File
PUD-98-006

**AMENDMENT TO BROOKMOOR PUD
COLORADO HOMES AND LIFE STYLE and MARTIN DELOHERY**

**AMENDMENT TO BROOKMOOR PUD
COLORADO HOMES AND LIFE STYLE AND MARTIN DELOHERY**

A request by Colorado Homes and Life Style and Martin Delohery to amend the existing Development Plan for Brookmoor. The property is currently zoned PUD (Planned Unit Development) District. The proposed changes are: revise entrance and gatehouse area, reduce setbacks, delete sidewalks, replace perimeter fence with landscaping, change fence along Woodmoor Drive to split rail and add a six foot berm along Lake Woodmoor Drive. The property is located on the north side of State Highway 105, south of Lake Woodmoor Drive and west of the westerly terminus of South Park Drive in the Woodmoor area. Tax schedule #'s 71141-00-012, 013. Approval includes authorization for the Chairman to sign the Development Plan/Guide and all other necessary documents to complete the rezoning process.

BROOKMOOR P.U.D. DEVELOPMENT PLAN CERTIFICATIONS AND DETAILS			
PROJECT NO. 97093.1	Drawn By: DebK	Date: 09/09/94	
	Checked By: RAM	Sheet: 1 of 3

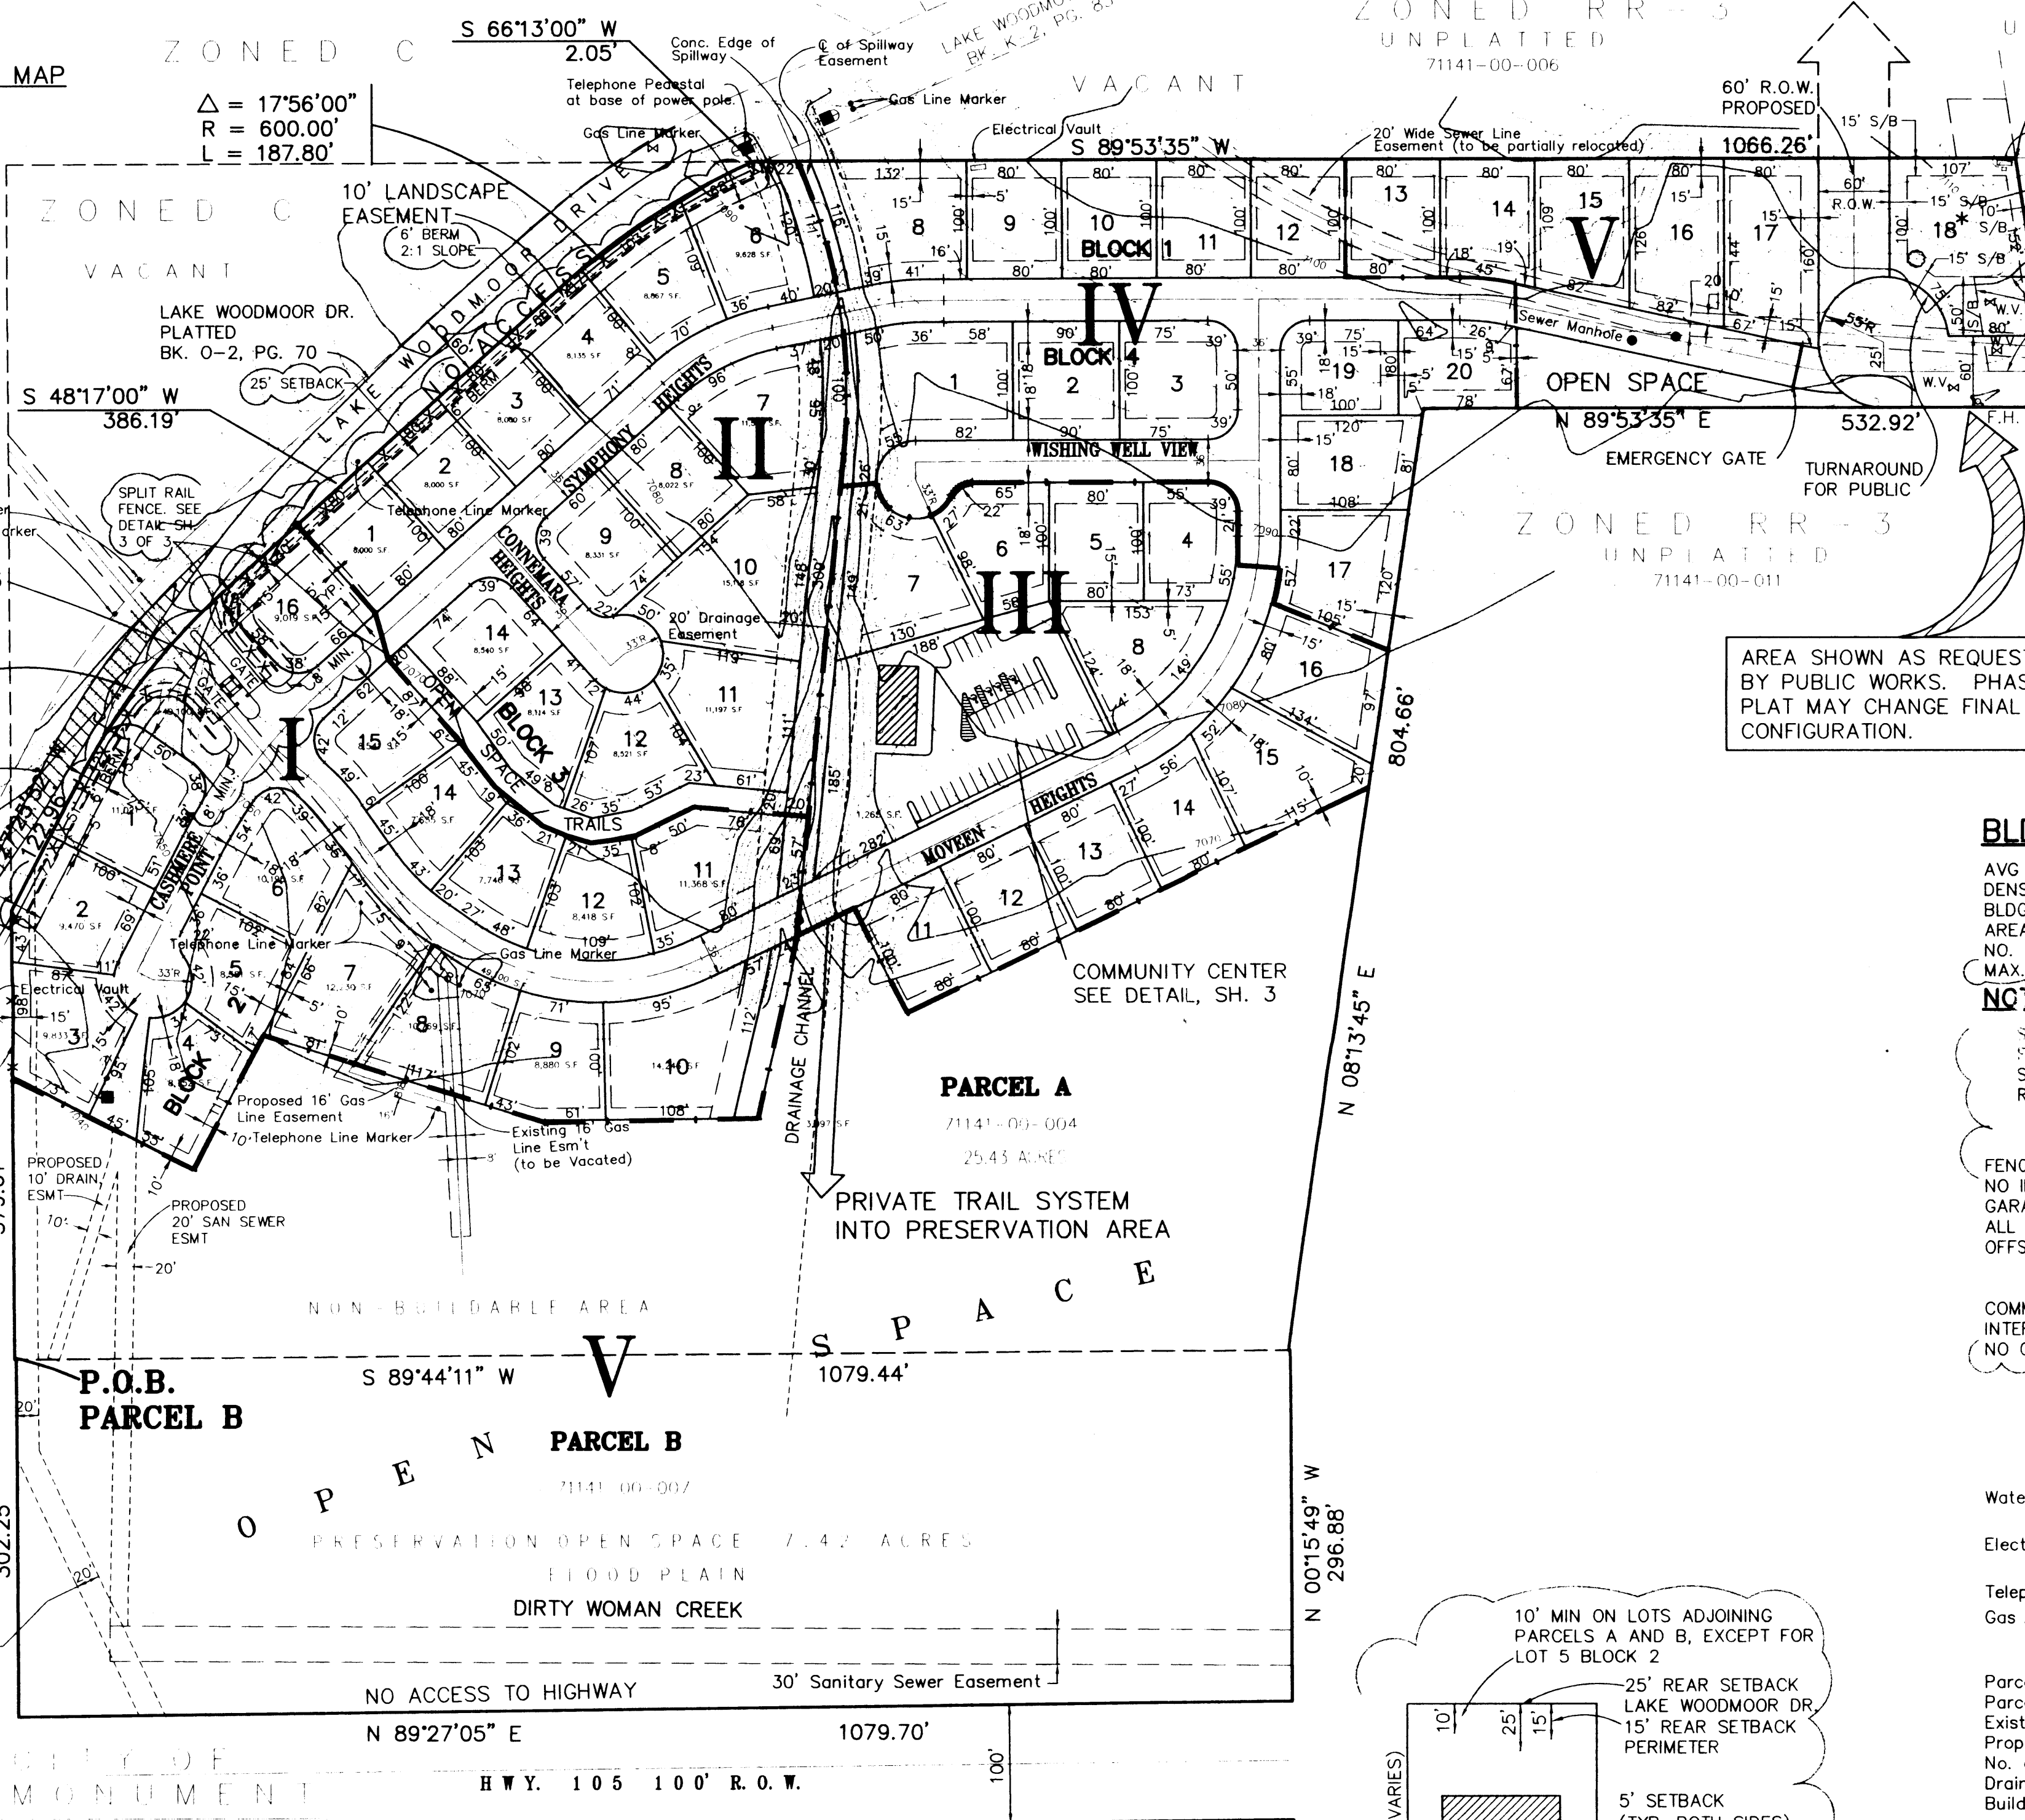
- 1) The proposed changes in building setback requirements appear to be somewhat confusing.
How will this provision be enforced when building permits sought for the homes?

- 2) Similar to paragraph 1, plat note number three is obviously intended to regulate the height of the buildings. While this is an appropriate and laudable goal, it also appears to employ cumbersome and convoluted language that will likely make enforcement of this provision without benefit of a topographical map more difficult than it needs to be. The Town would recommend a blanket provision with no contingencies.

EL PASO COUNTY DEPARTMENT OF TRANSPORTATION (response to September 15, 1998 request) - The P.U.D. Development Plan indicates a different berm cross-section and access configuration from what is shown on the construction plans. The revised grading on the construction plans is not clear. Assuming the construction plans are correct, the berm (and proposed vegetation) will need to be removed near the entry road to provide safe sight visibility for vehicles entering and leaving the subdivision.

Please resubmit the grading and erosion control of the berm as a detail at a revised scale.

A twenty-five foot sight triangle needs to be provided on the Development Plan on either side of the access point.

The original changes to the setbacks appeared confusing. Staff requested the developer to list the setbacks specifically on the plat, if they are different from the overall setbacks, so there is not confusion when people are applying for a building permit. There are various people who may approve plot plans and determining the correct setbacks should be as clear as possible. Those changes have been made on the revised plat.

The notes regarding the building height were also confusing. The developer has changed the note on the revised plat per staffs request.

9 ③ A twenty-five (25) foot sight triangle shall be provided on the Development Plan on either side of the access point.
